Consultation Response from KC, Trees
2025/91531 land off, Leeds Road, Heckmondwike, WF16 9DB
REVISED AND ADDITIONAL INFORMATION RECEIVED, AND REVISED DESCRIPTION: Demolition of existing semi-detached houses and associated buildings, and construction of 49 dwellings, including associated access and other associated works
Date Responded: 8/4/26 Responding Officer: Irving Responding Ref:

Date:	29.04.2025	Project:	Leeds Road, Heckmondwike
Scale @ A1:	1:500	Drawing Number:	2403-02-001
Drawn By:	CC	Revision:	G
		Drawing Title:	SITE PLAN

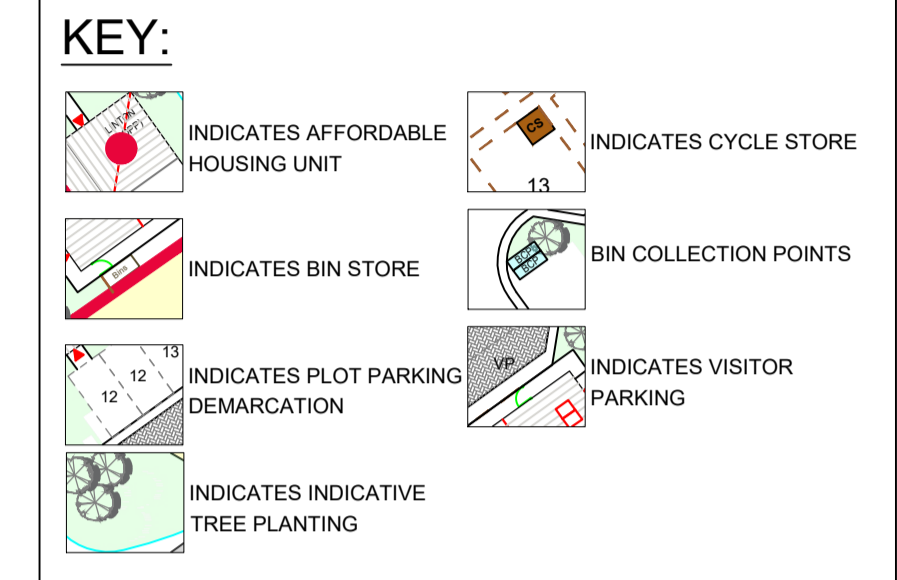
Overall, the plans appear to be improved, as most offsite trees now appear to be adequately protected from the development, which will allow for existing boundary screening to be retained. However there remains the issue of the incursion of construction into the RPAs of T02 and T03. These incursions cannot be permitted as it would seriously threaten the health of the trees.

As per my previous consultation, **T3 is a Category B, offsite sycamore** and it is proposed to construct a significant amount of new hardstanding within the RPA, exceeding the 20% limit recommended in BS5837:2012. T3 contributes significantly to local amenity and offers many environmental and ecological benefits, therefore the proposals must be altered to reduce the hardstanding within the RPA to avoid long-term detrimental health impacts to the tree.

Also, again I bring your attention to another significant tree which overhangs the site boundary, which has not been included in survey. The stem is located within the rear garden of 85 Popeley Road. There are no proposals currently affecting this tree, likely due to the presence of the drainage easement in this area. However, this tree must also be protected from any development.

There remains a holding objection from an arboricultural perspective, subject to amendments to reduce the impacts, as discussed. The proposal conflicts with adopted Kirklees local plan policy 33 and 24 (i)
